**RE: Sundance Construction – Beverly Hills
Grading and Drainage Plan
Engineer’s Stamp Date: 01/24/18
Hydrology File: B18D023**

Based upon the information provided in your submittal received 01/24/18, the Grading and Drainage Plan **is not** approved for Building Permit. The following comments need to be addressed for approval of the above referenced project:

C-100

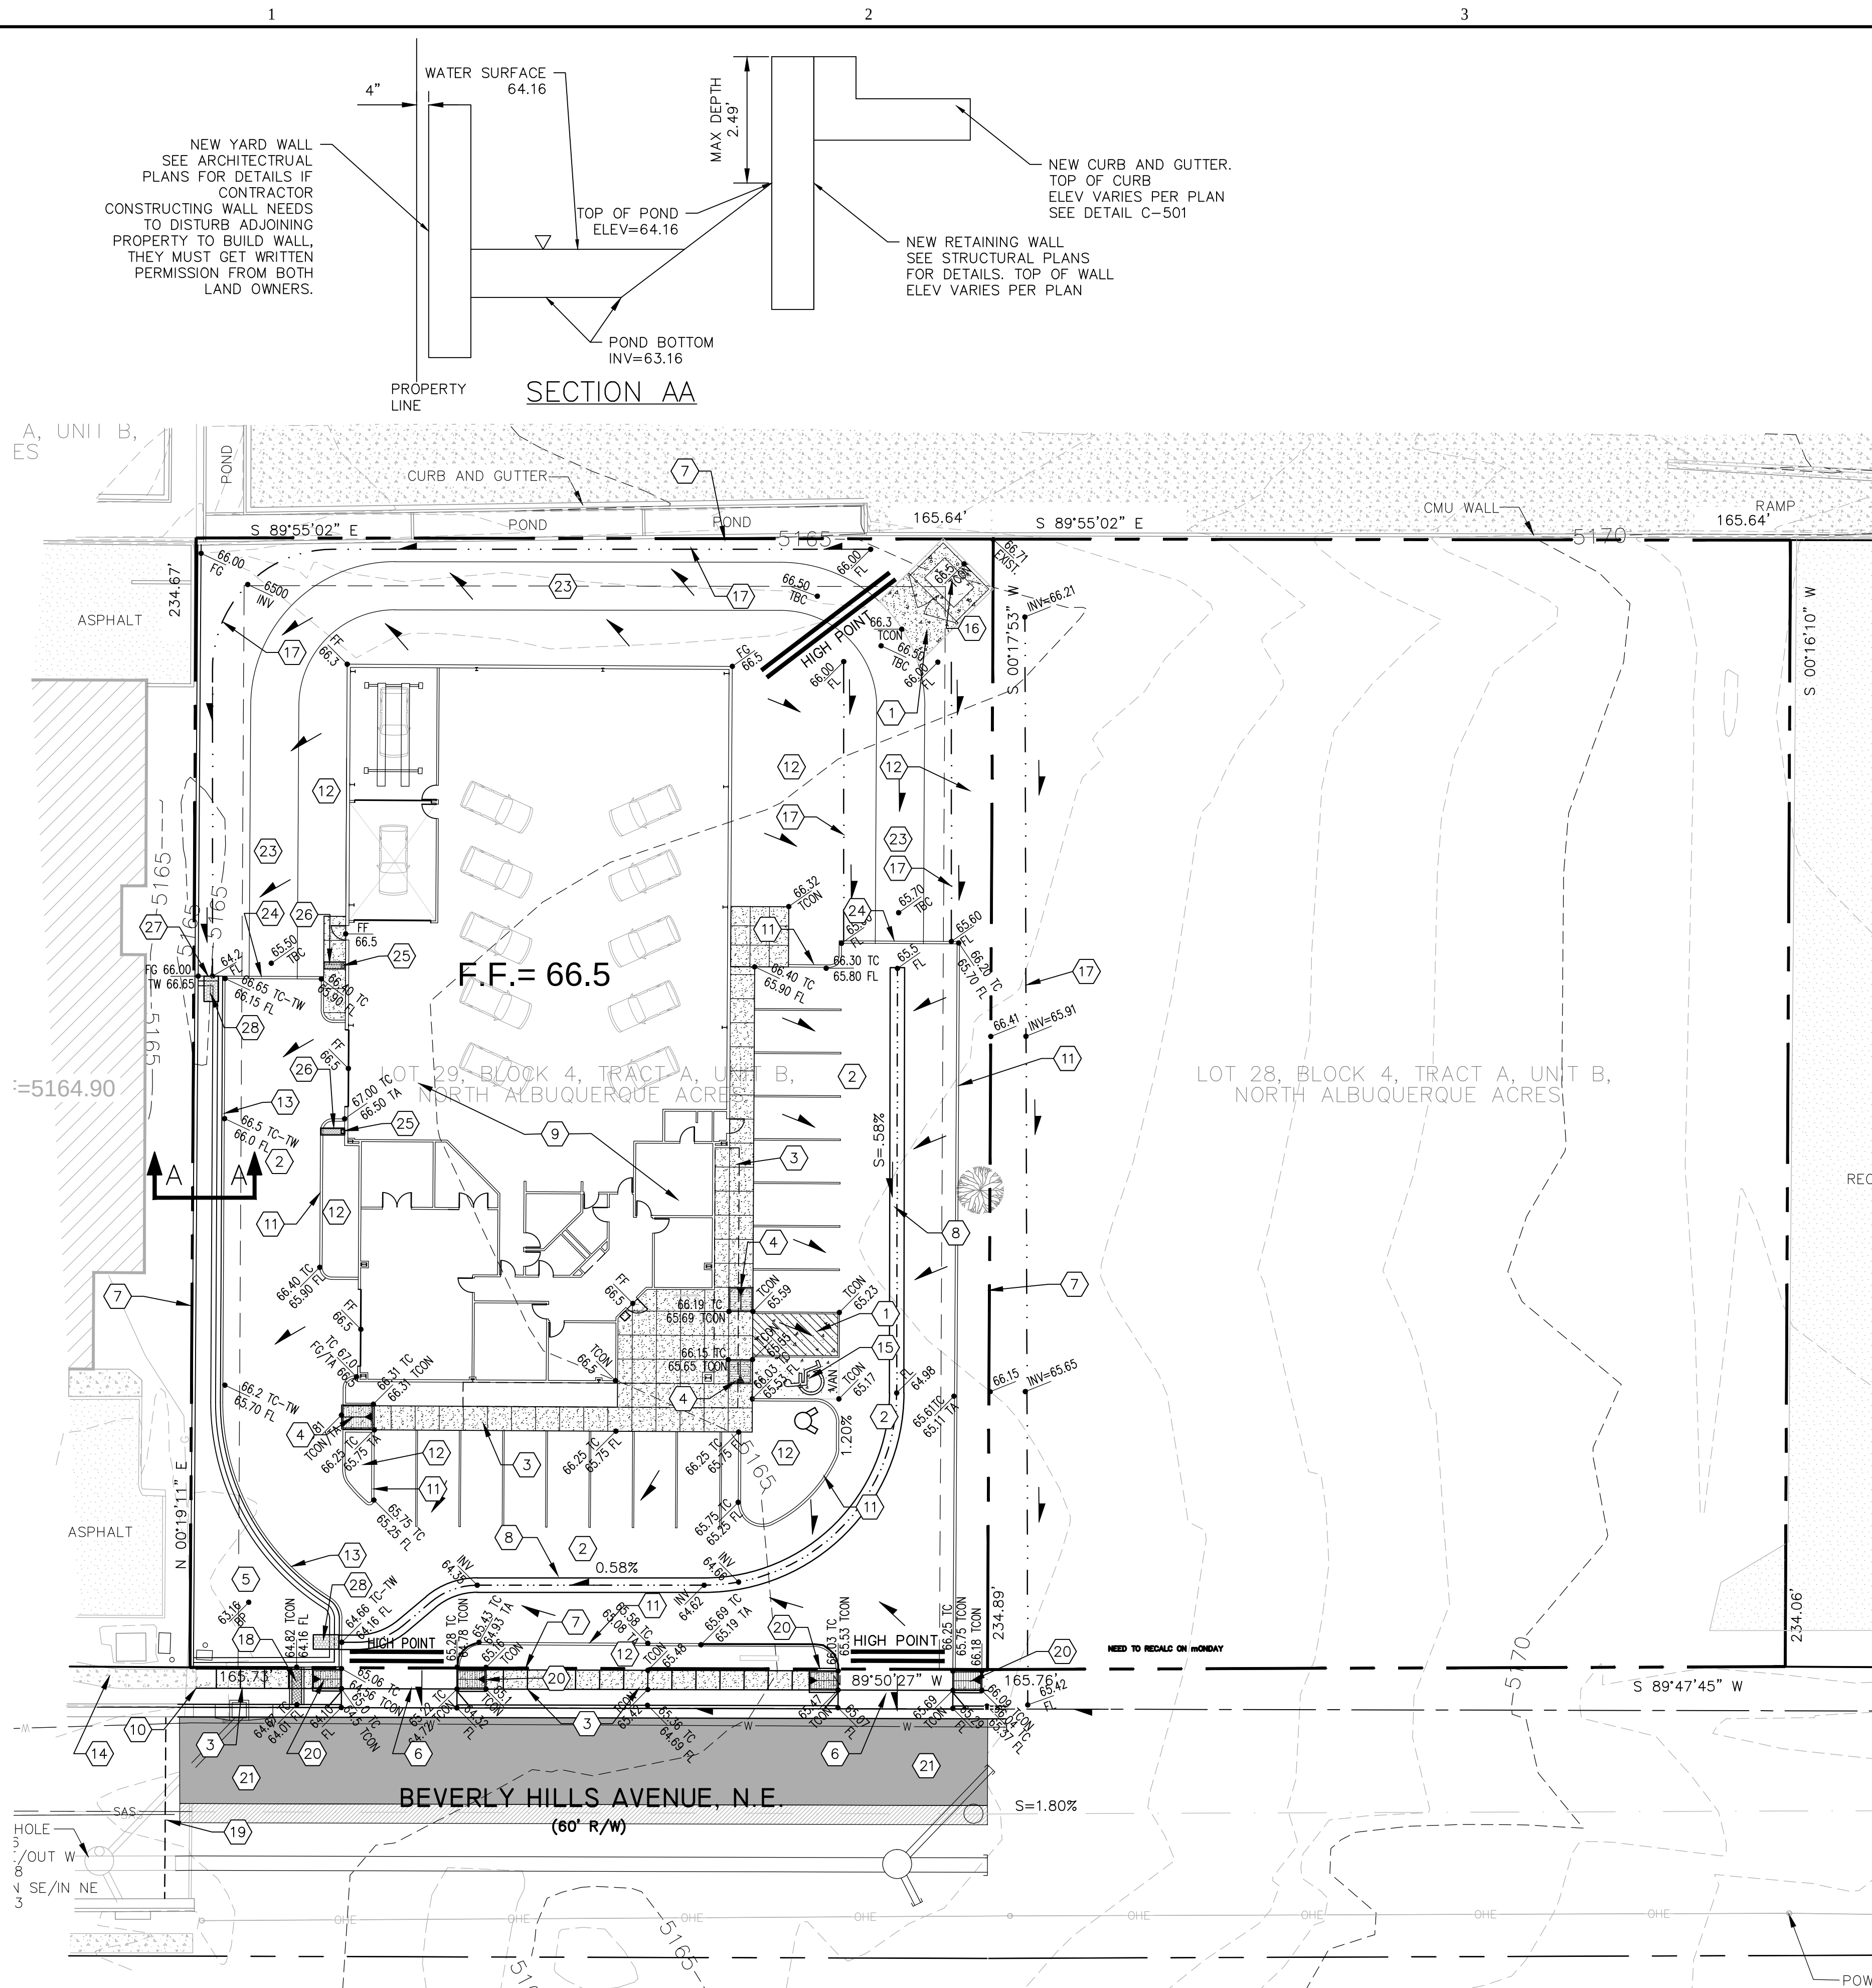
1. Sheet C-100. Please provide the weir calculations for the curb cuts.
2. Sheet C-101. Key Note 7 states approximate location of property line. All property lines and existing topographic survey information must be accurate and not approximated. At the northwest corner, it appears that the adjacent pond is on this property. Please submit a surveyed property. If the property lines are properly surveyed, then delete the word approximate location of property line from Key Note 7.

C-101

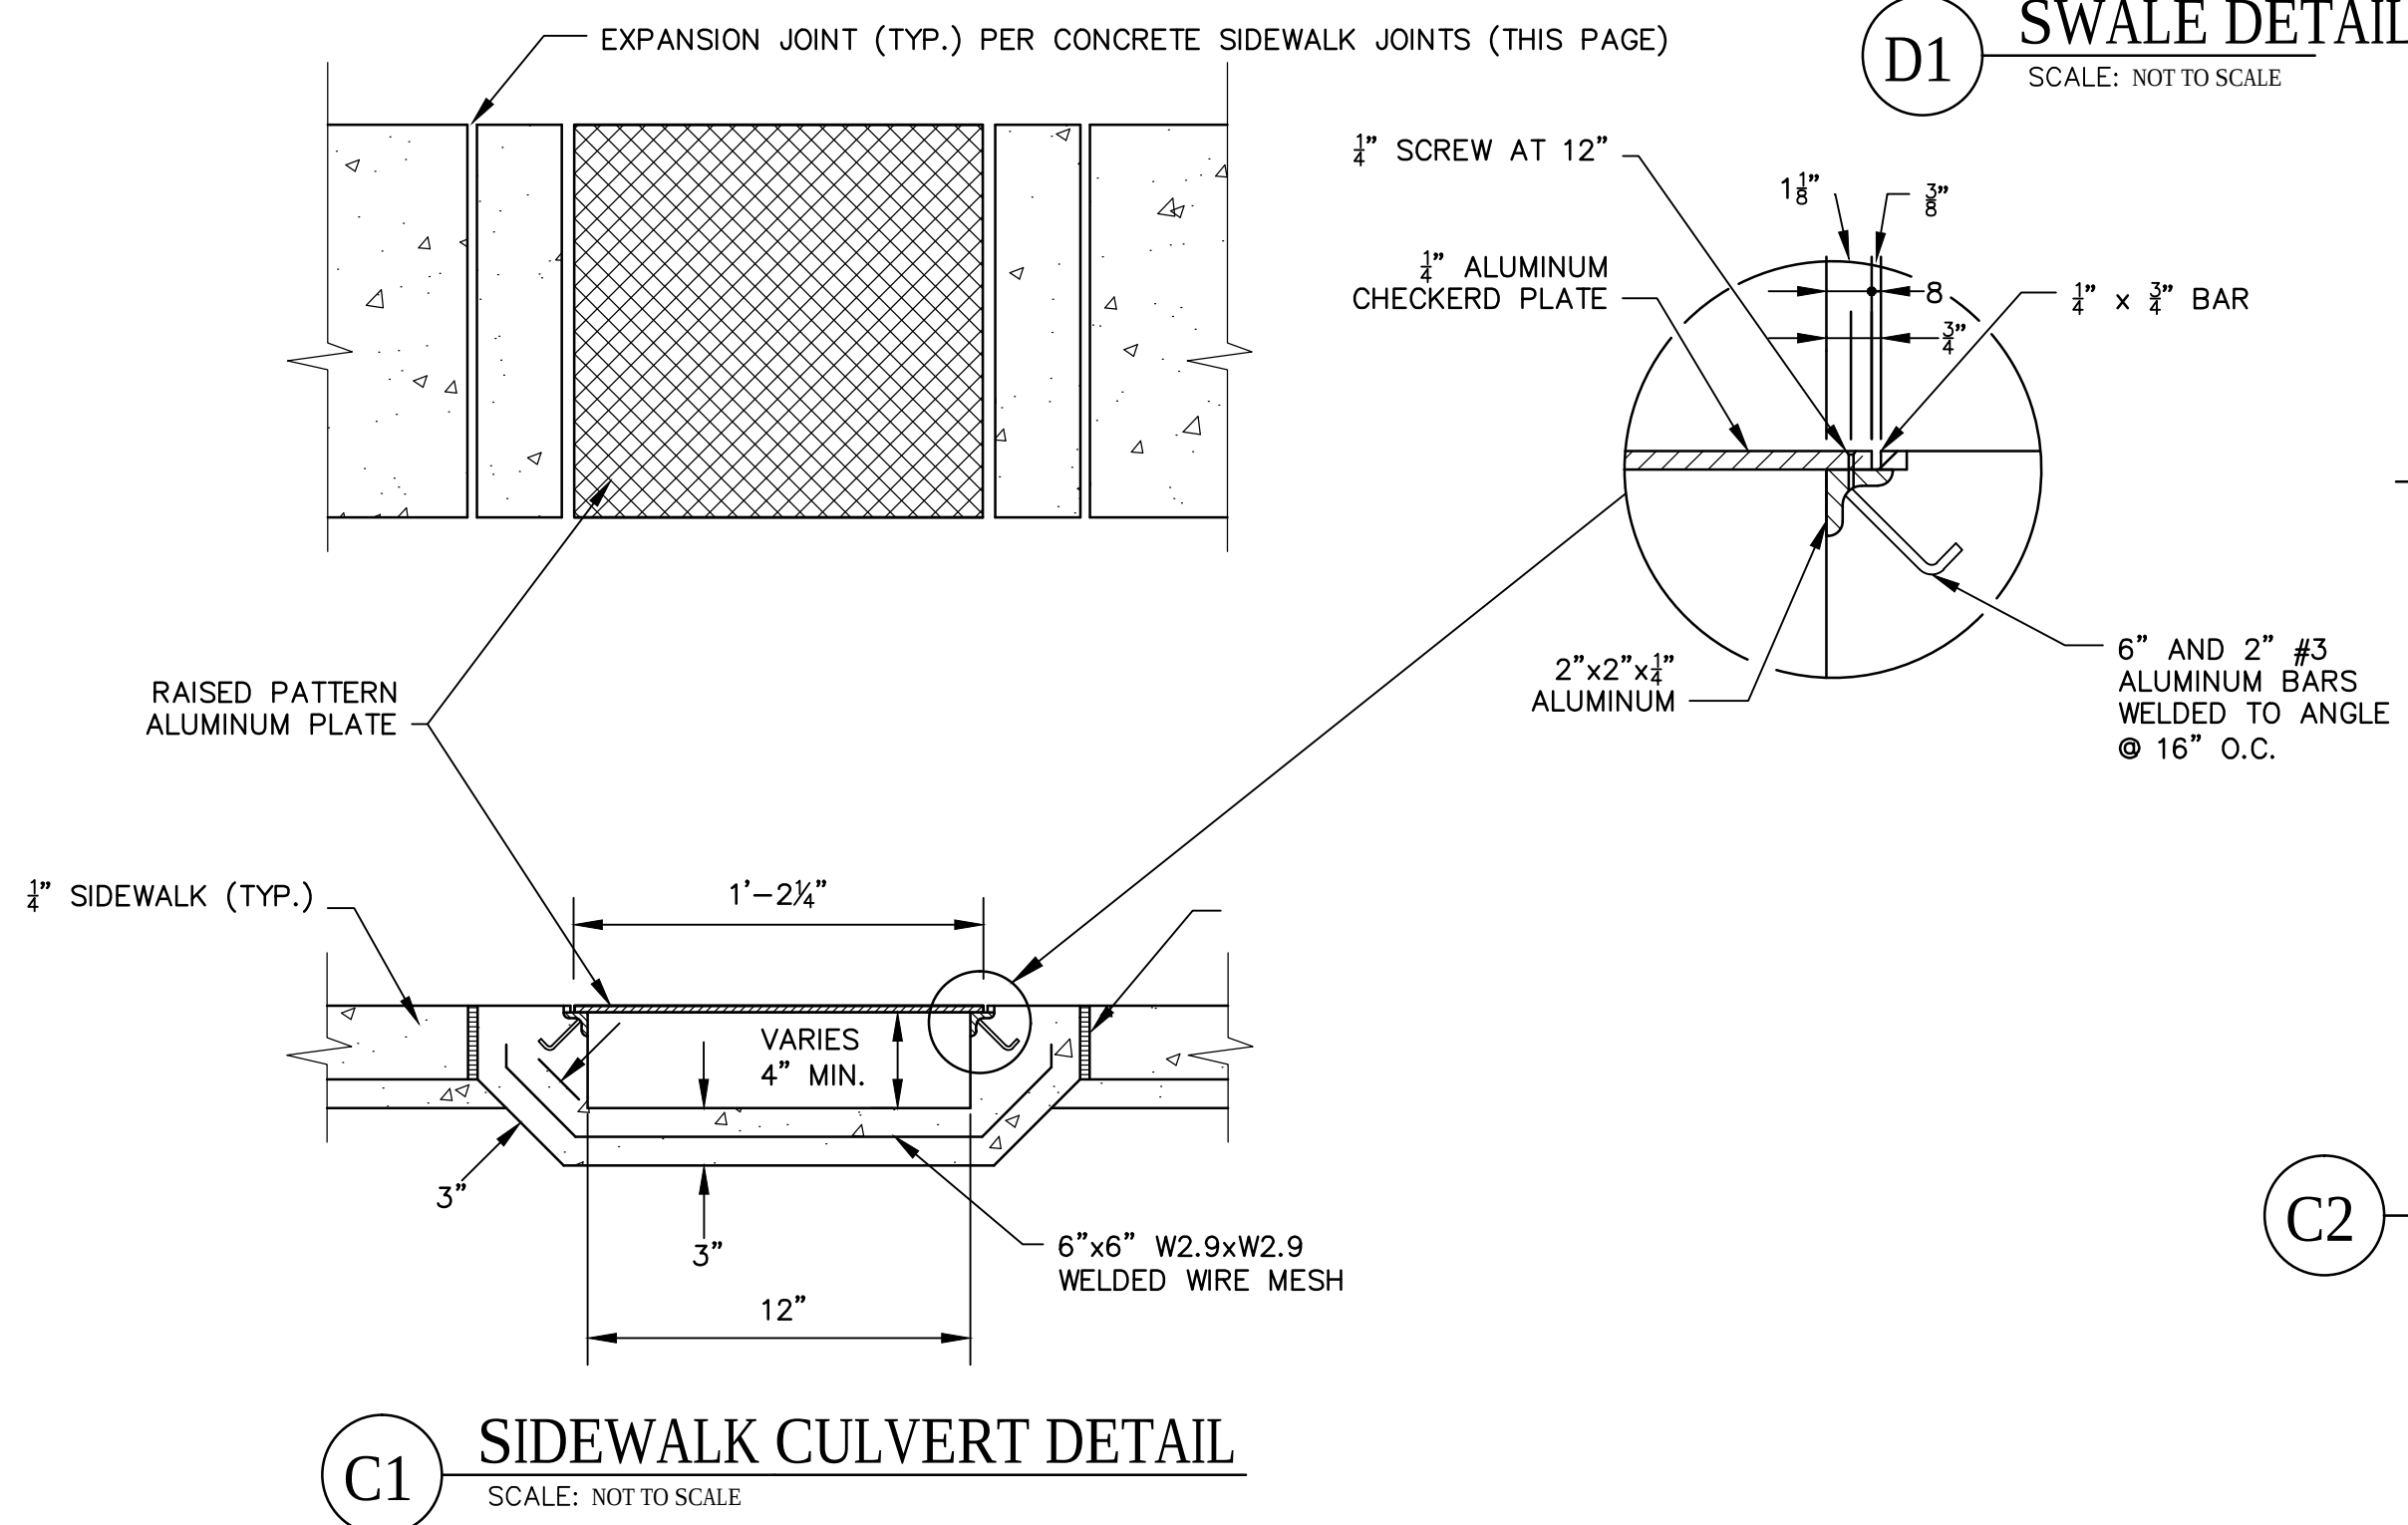
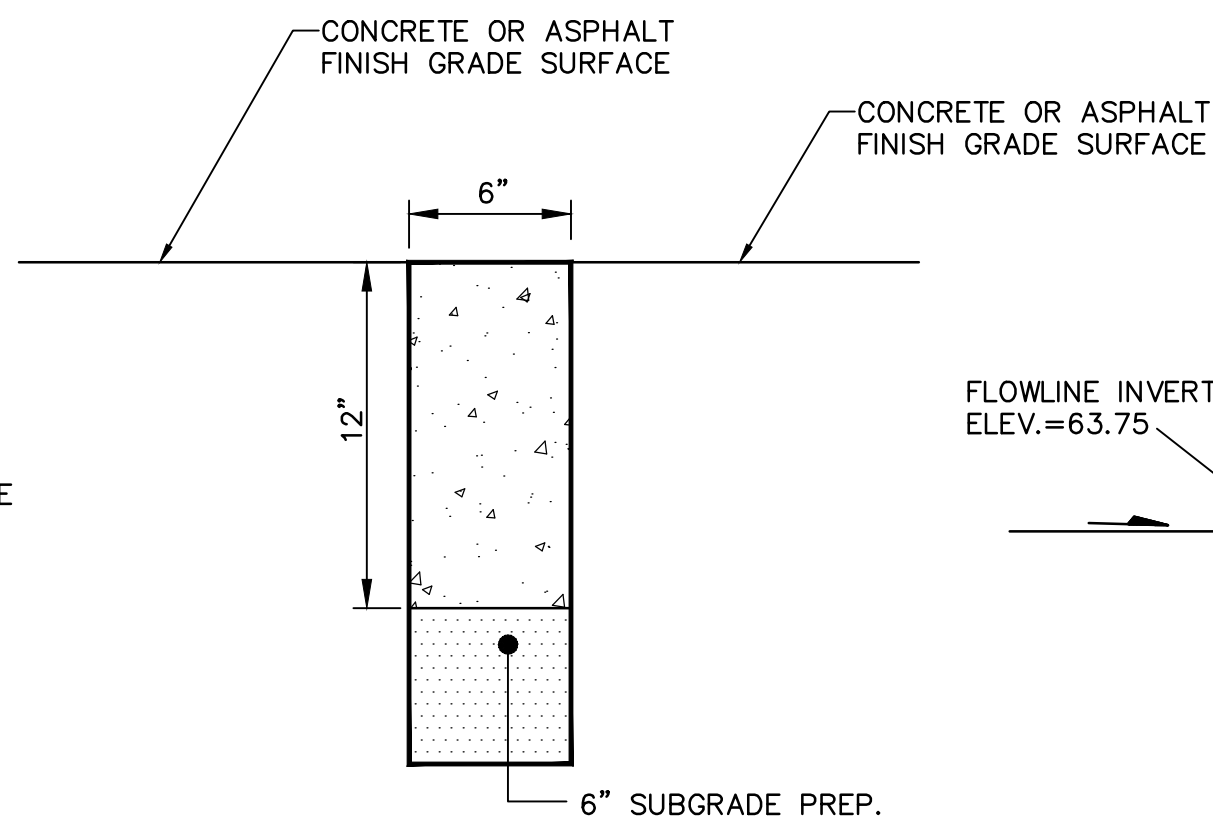
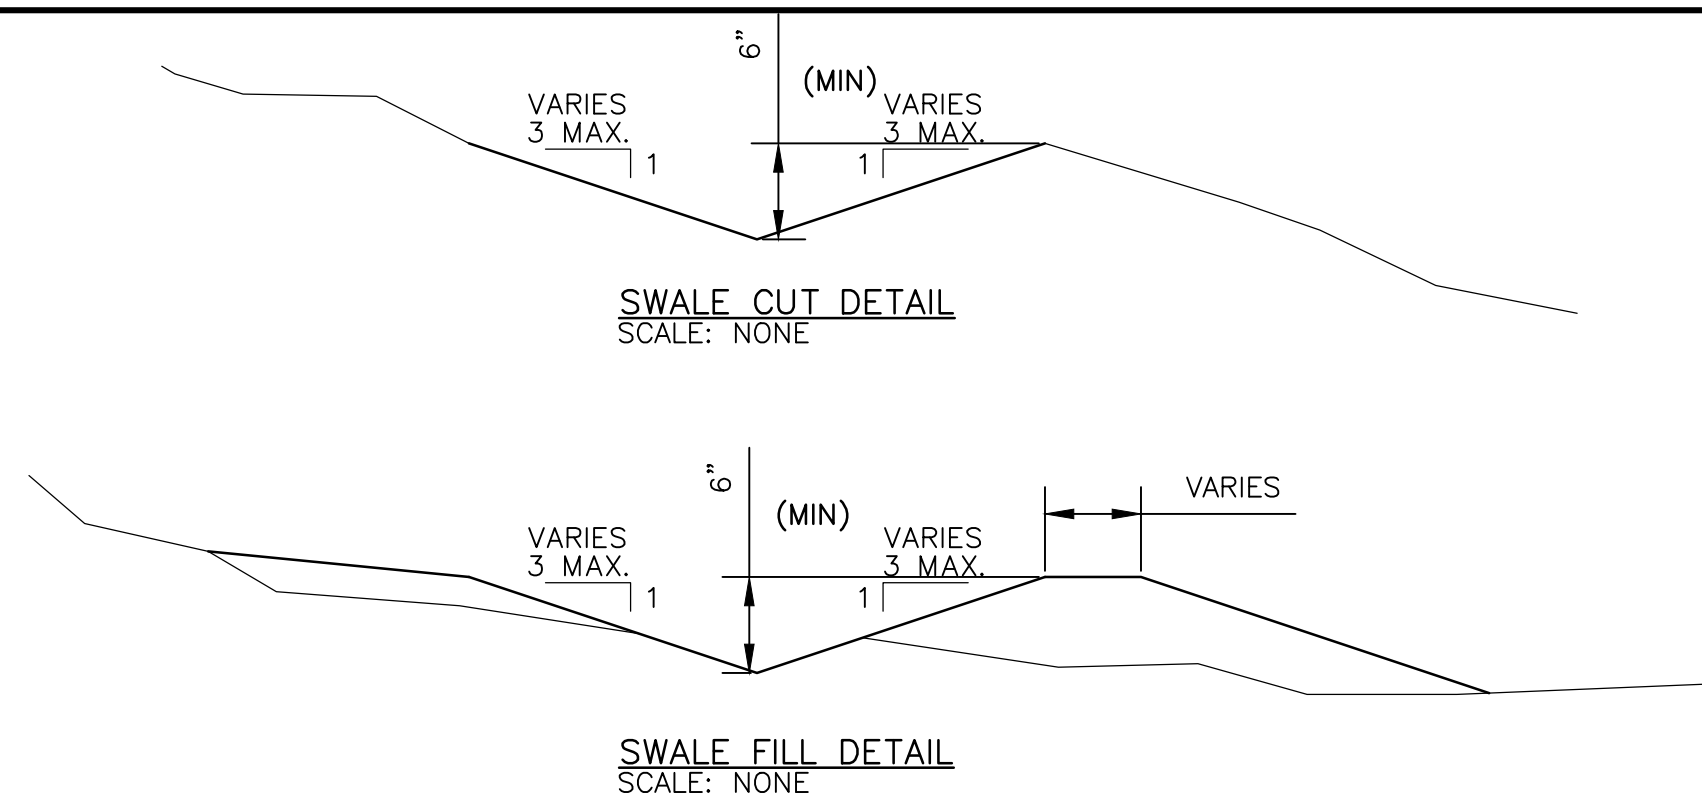
3. Sheet C-101. Please provide a written agreement from Lot 28 property Owner stating that grading can be conducted on their property for the benefit of Lot 29. If an agreement cannot be obtained, then the swale to divert off-site drainage to Beverly Hills will have to be within the project’s boundary.

4. Sheet C-101. Please add the flowline information at the start of the diversion swale at the east side of the property.

5. Sheet C-101. Key Note 22. This pond is just pointing to an open area. Is there supposed to be a first flush pond here?? It appears that all first flush volume is included in the pond to the southwest corner of the property.

6. Sheet C-101, Section A-A. Please show the property line and dimension of the wall from the property line.
7. Sheet C-101, Section A-A. Per DPM Ch. 22.5.B, grading and construction of retaining walls at or near the property line must demonstrate that the adjacent property is not damaged or its use constrained. Any such encroachment by the wall or grading must be accompanied by written permission of both landowners. Therefore the wall may have to be moved away so that the footer does not impede the adjacent property.

8. Sheet C-101. Please show the half street, storm drain, and inlet which is to be constructed with the work order. Please add a note that all work within Beverly Hills Ave will be part of Work Order #722084.
